A/125/21/L

Weavers Cottage Weavers Hill Angmering BN16 4BP

Listed building consent to locate bin storage within site boundary by partially removing and reforming the existing flower bed to sit flush with flint garden wall.

PROPOSED SITE PLAN - NEW BIN STORE

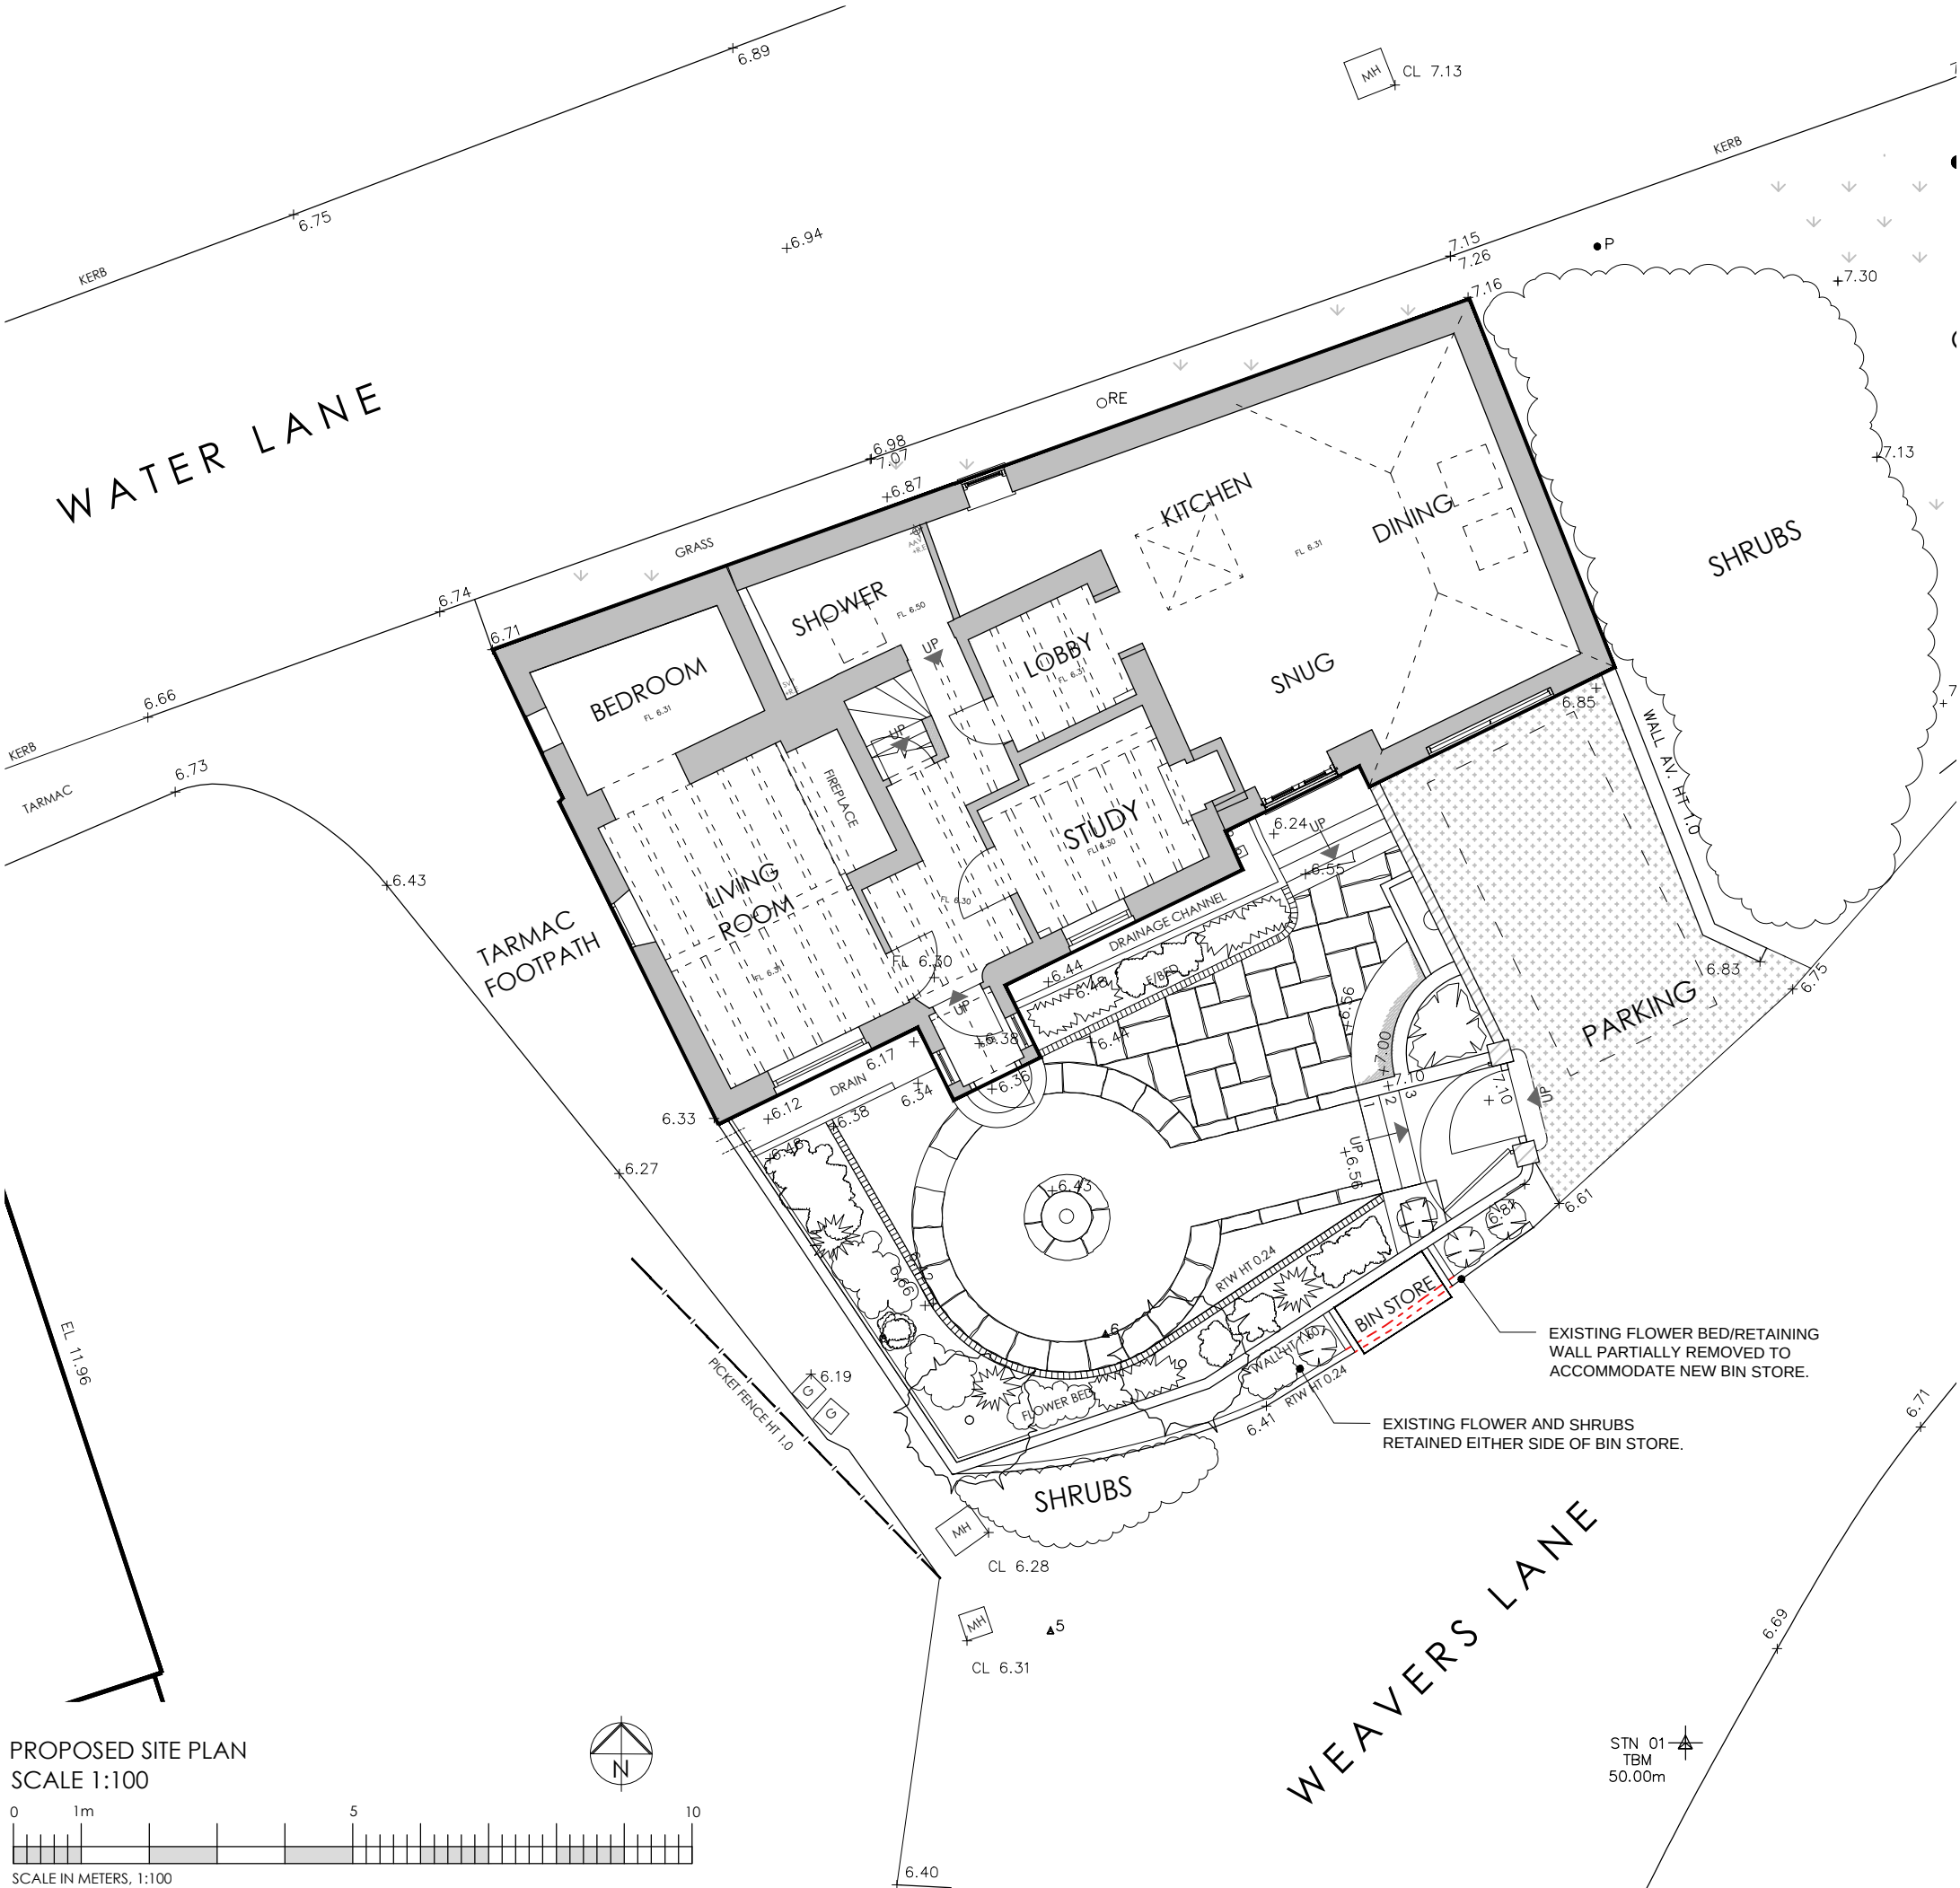
The bin store would be a simple wooden structure with doors on it, which the plans indicate would be painted the same colour as the existing joinery. Its location would mean that it would be seen from the lane to the front of the property and potentially in the context of the front elevation of the building. However, I am also aware that the site is constrained which means that there are few opportunities to locate such a structure elsewhere. The property owner also currently uses the location to store the bins and they do not enhance the appearance of the listed building at present. Further, the structure is a ‘temporary’ one and could easily be removed.

A site visit has established that the current joinery for the house is painted white, and it is assumed that the intention is for the new structure to be the same colour. This would create a stark addition to the front of the property and street-scene, and it is questioned why a more neutral colour which is more closely related to the flint wall could not be chosen. I am thinking of a more cream colour similar to the existing mortar.
